A66 Northern Trans-Pennine Project

7.46 Applicant's Response to Deadline 7 Submissions

A66 Northern Trans-Pennine Project
Development Consent Order 202x

**7.46 APPLICANT'S RESPONSE TO DEADLINE 7
SUBMISSIONS**

Suitability	Suitability Description	Revision
A	Approved for Stage Complete	C02

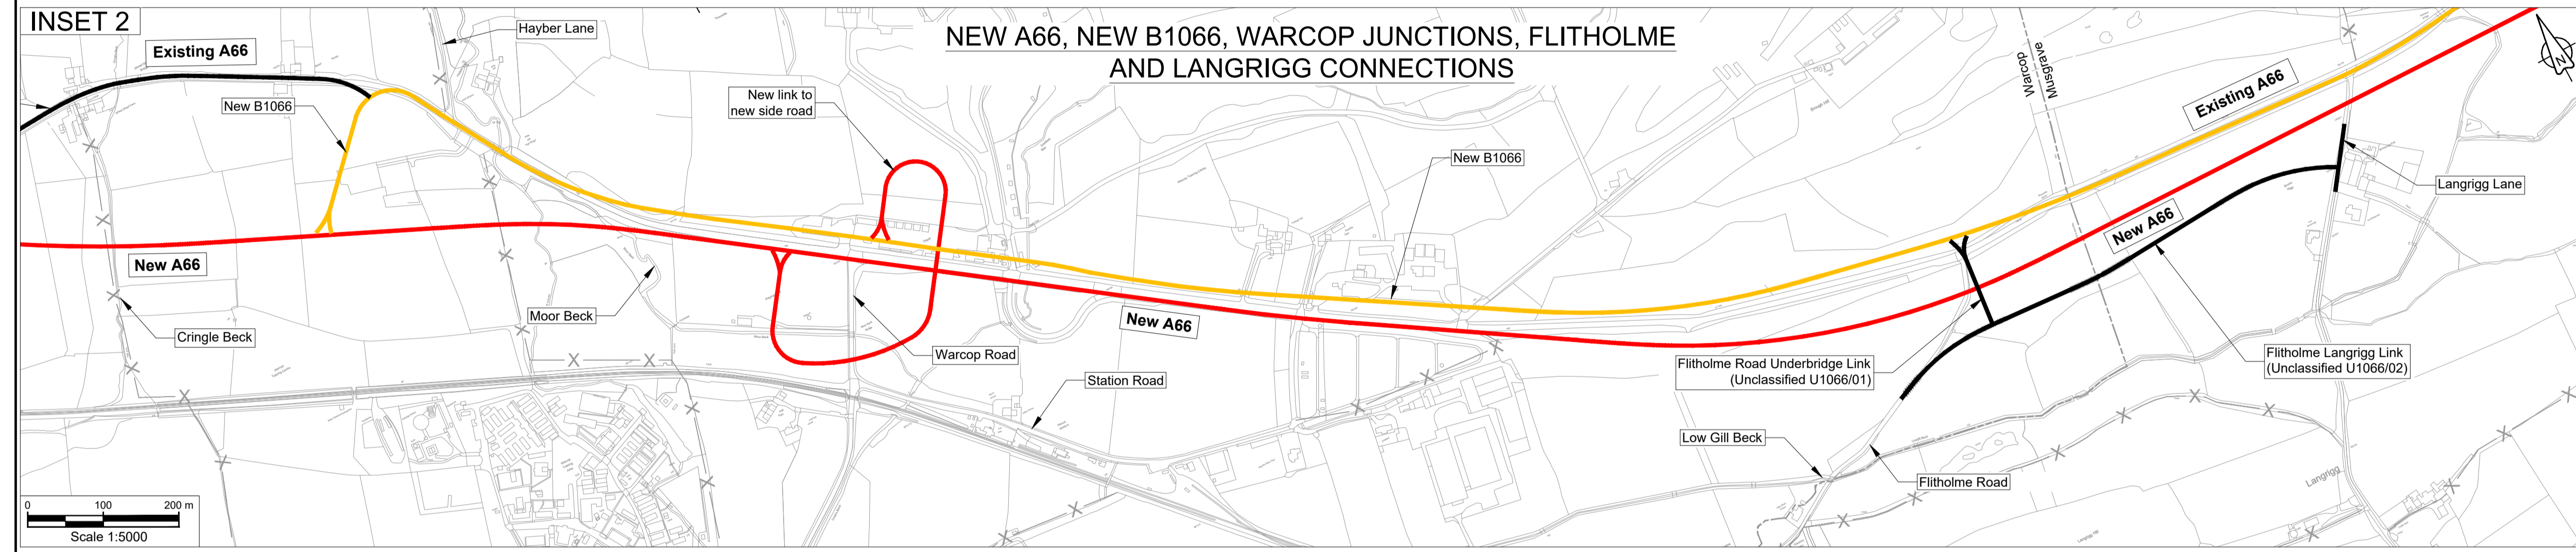
Examination Library Reference	Interested Party and Title of Submission	Issues Raised	Applicant's Response
		<p>DC-19 – Realignment of cycleway local to Cringle and Moor Beck</p> <p>Given that the proposed route will need to cross a 50mph road at a corner, the design will need to be amended to incorporate a safe crossing for non-motorised users. Compliance with LTN 1/20 crossing types is required (signals or grade-separation), given the likely speed and volume of traffic.</p> <p>DC-24 – Reuse of existing A66 (north of Flitholme)</p> <p>No further comments</p> <p>DC-26 - Revision to West View Farm accommodation bridge and removal of West View Farm underpass</p> <p>The Council is still concerned that overall connectivity for PRow users is not maintained.</p> <p>Latest plans clarify that the new bridleway (marked as 309/031) is retained with the changes.</p> <p>DC-27 – Construction of noise barrier south of Brough</p> <p>No further comments</p>
